To: David Pettine, CMPC  
From: Ashley Botkin - Planning, Design, and Development  
Date: February 20, 2020  
Rezoning Petition #: 2019-178 Revised

RZ1.0

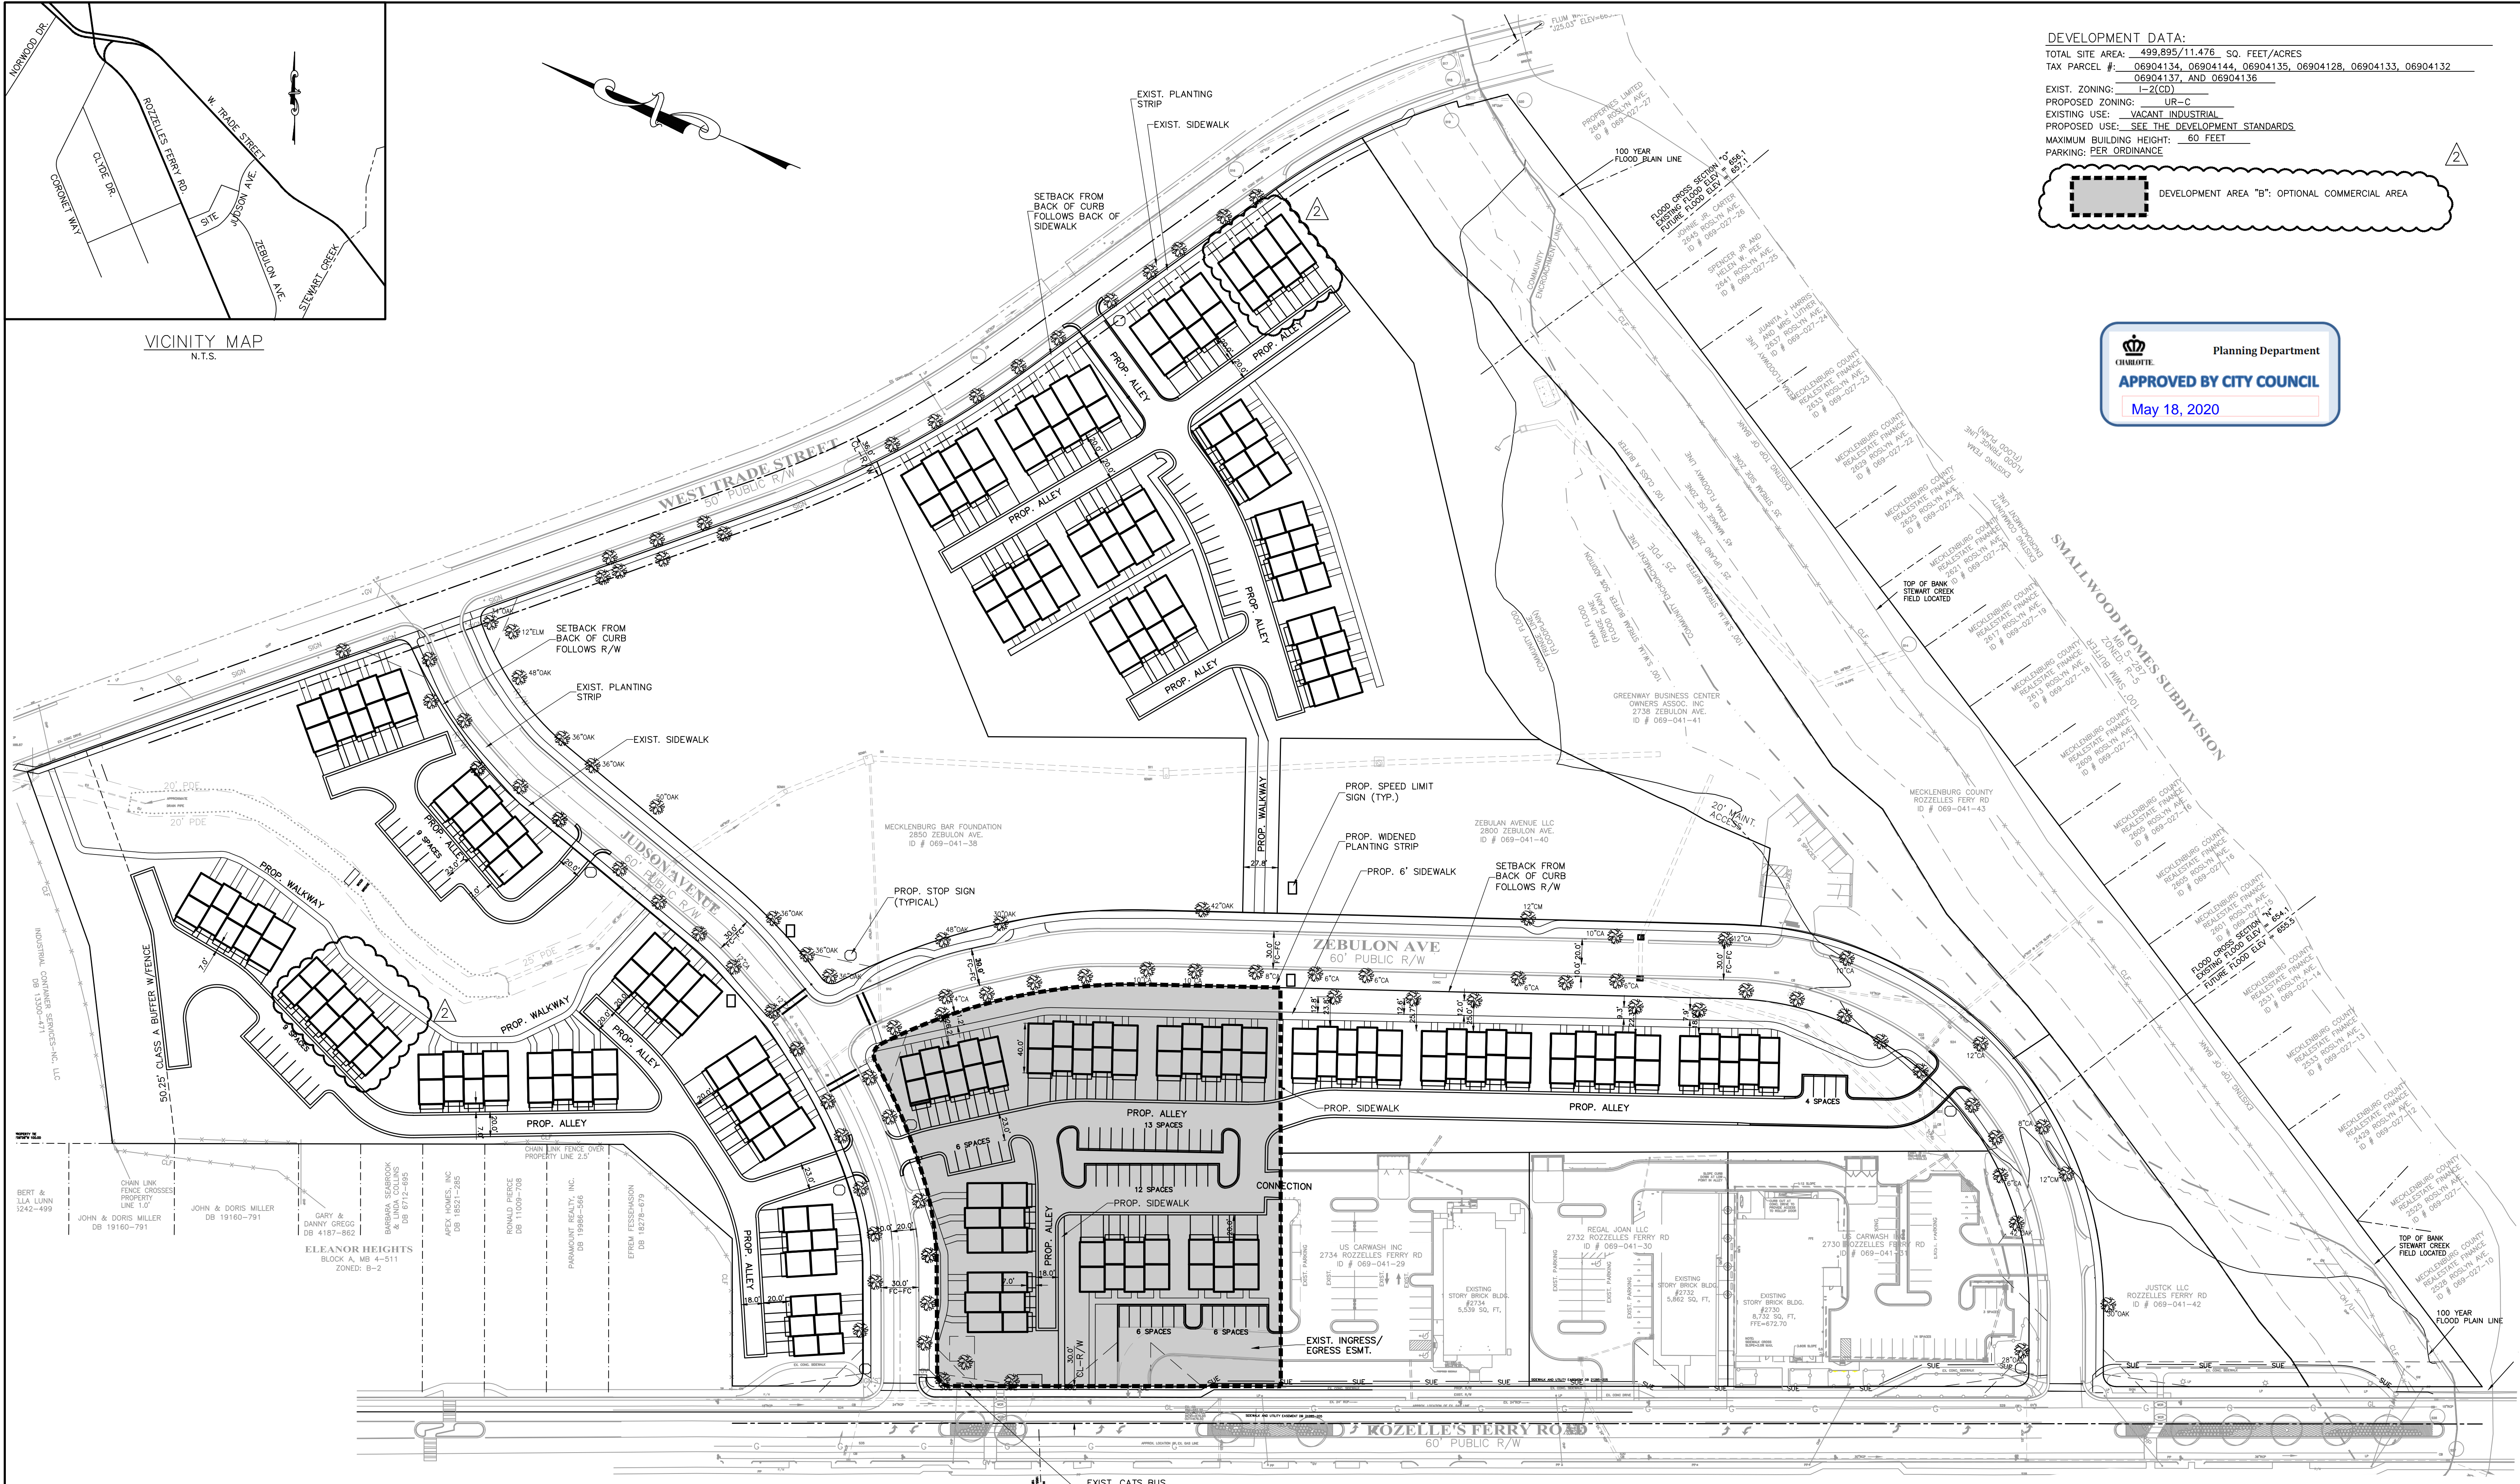
Craig Robinson (Urban Forestry) – Tree save was not required in 2007 and this property is not part of the 2019 rezoning. Need to show 15% tree save area on the parcels you are rezoning.
